Variation of condition 2 imposed under EP/59/17/PL relating to approved plans concerning updated site plan & ground floor plan.

Tudor Lodge 125A Sea Road East Preston

Thank you for your internet representation made on 6th November 2018 which has been recorded as '**an objection**' with the comments as follows:

Ground Floor Plans

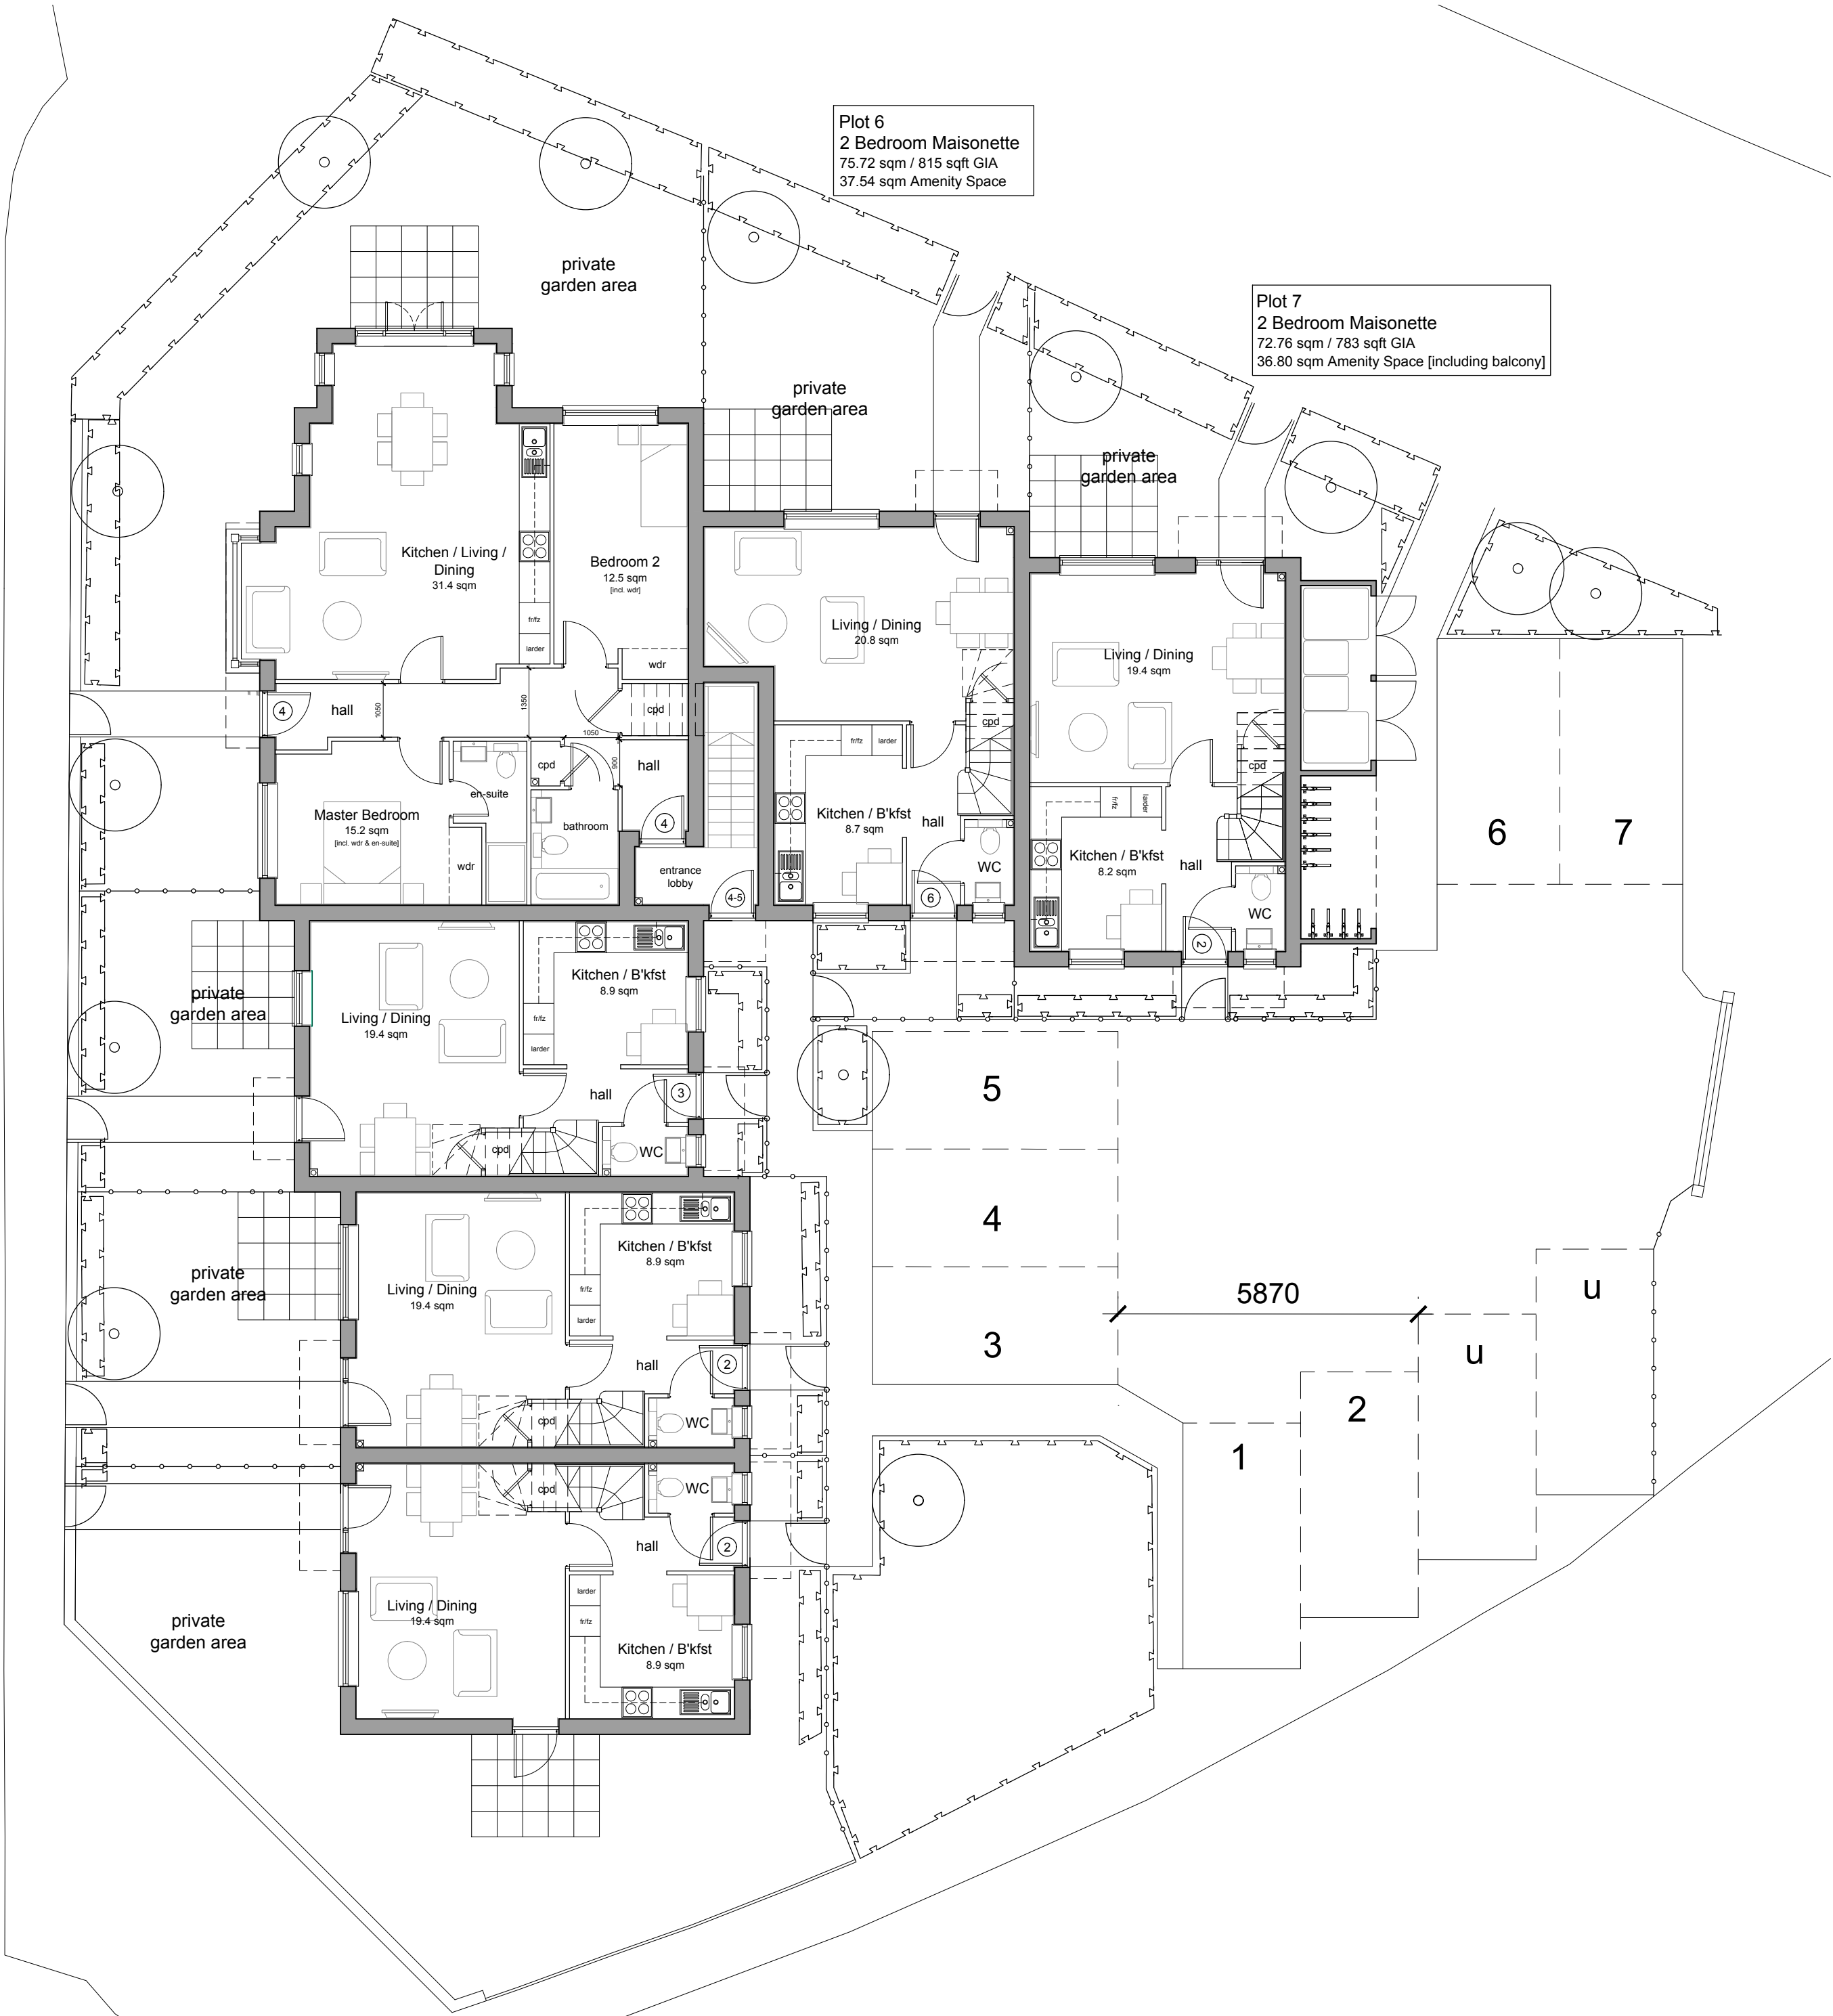
I object to the application to change the parking layout as this access encroaches on to the forecourt of Palm Court Cottages and causing even more disruption, with vehicles coming right up to my front window. The area in front of Palm Court Cottages is a forecourt for the cottages which some owners have maintained for 20 plus years and not an access road for the development.

It was understood that the access to the site would be straight off South Strand, which deliveries and workman have been using during the development with no problem and without using our forecourt.

Since living at Palm Court for over 20 years we have had no problem with parking our vehicles outside our house, now 2 owners have to park on South Strand as they are unable to park outside their house due to the development.

All these adjustments to planning are now showing how over developed the site is.
